Light Valley Solar

Statement of Common Ground with Environment Agency

Document Reference: EN0110012/APP/LVS/08.26

Deadline 3 Submission

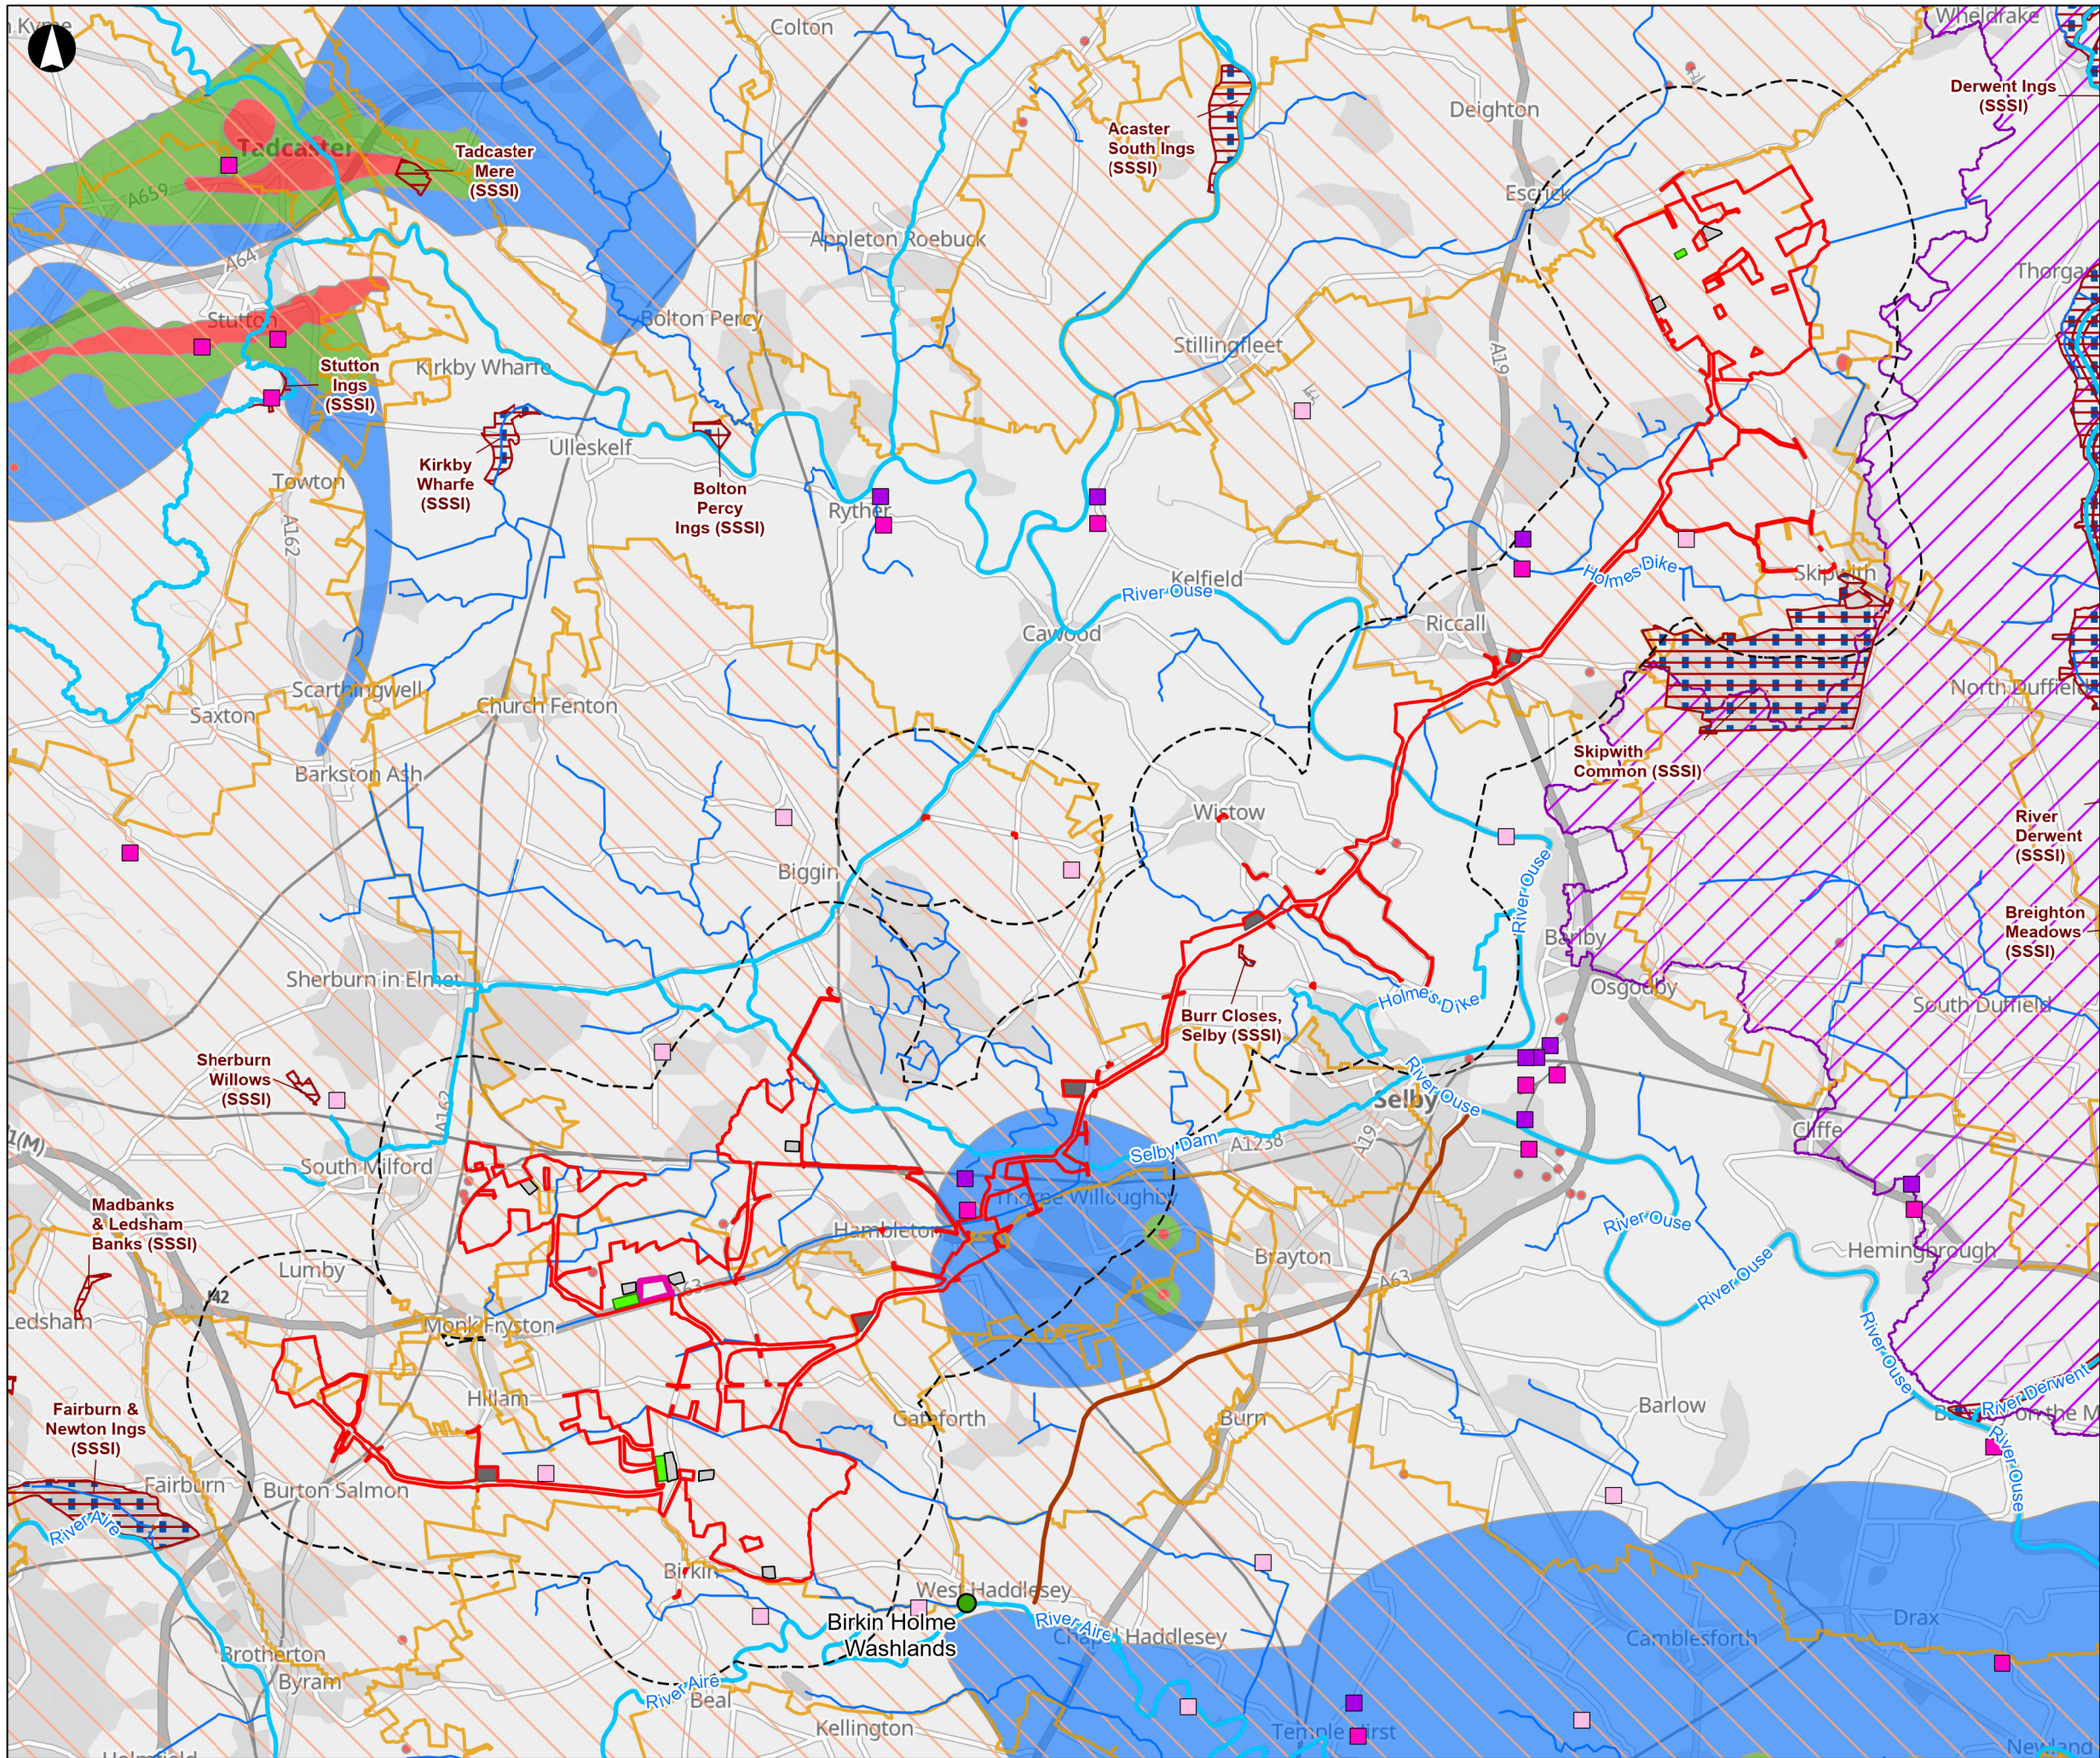
RR ref EA29	Retaining Access to Monitoring and Sampling Points	In its RR, the EA set out that Chapter 15 states that there are no river flow or level gauging stations within the Order Limits or Study Area, and that five hydrometric monitoring stations are present within the Study Area. The EA stated that their records show there are several surface water and groundwater monitoring and sampling points within the Proposed Development footprint. In its response to Applicant's responses at D1 the EA noted that Chapter 15 - Water Resources and Flood Risk should be updated to include the information set out in its response.	A response was issued to EA29 in The Applicant's Response to Relevant Representations Part 1 [PDA-014]. A response was issued to WR-EA-028 at Deadline 2 in The Applicant's Response to Submissions Received at Deadline 1 – Statutory Bodies, stating that Chapter 15 and Figure 15.4 have been updated for D2 to add the required details.	Agreed

Row ID	Topic	EA position	Applicant position	Status
		Having reviewed the Applicant's response and updated documentation, the EA position is that the submission of Figure 15.4 Groundwater and Surface Water Designations [REP2-052] adds an additional hydrometric monitoring point which they had identified. The EA notes that the Figure contains some errors and omissions, but the EA confirms that this issue is resolved in their D3 response.	Following the EA's latest comments, the Applicant agrees this is resolved. Figure 15.4 will be reviewed and any updates required will be made for Deadline 4.	
RR ref EA30	Retention of Cables Post Decommissioning	In its RR, the EA noted that decommissioning proposals include leaving most ground infrastructure below 1.2 mbgl in situ within Solar Development Sites. Cables left in situ may represent an unacceptable risk of pollution of controlled waters via degradation. In its response to Applicant's responses at D1 the EA noted that it was pleased to see that the oCEMP would be updated to include a commitment relating to cable construction, as requested. Having reviewed the Applicant's response and updated documentation, the EA position is that the updated outline CEMP [REP2-089 and REP2-090] contains a satisfactory commitment relating to the fate of cables post-decommissioning. The EA confirms that this issue is resolved in their D3 response.	A response was issued to EA29 in The Applicant's Response to Relevant Representations Part 1 [PDA-014]. The oCEMP been updated. This was shared with the EA and submitted at Deadline 2. Following the EA's latest comments, the Applicant agrees this is resolved.	Agreed
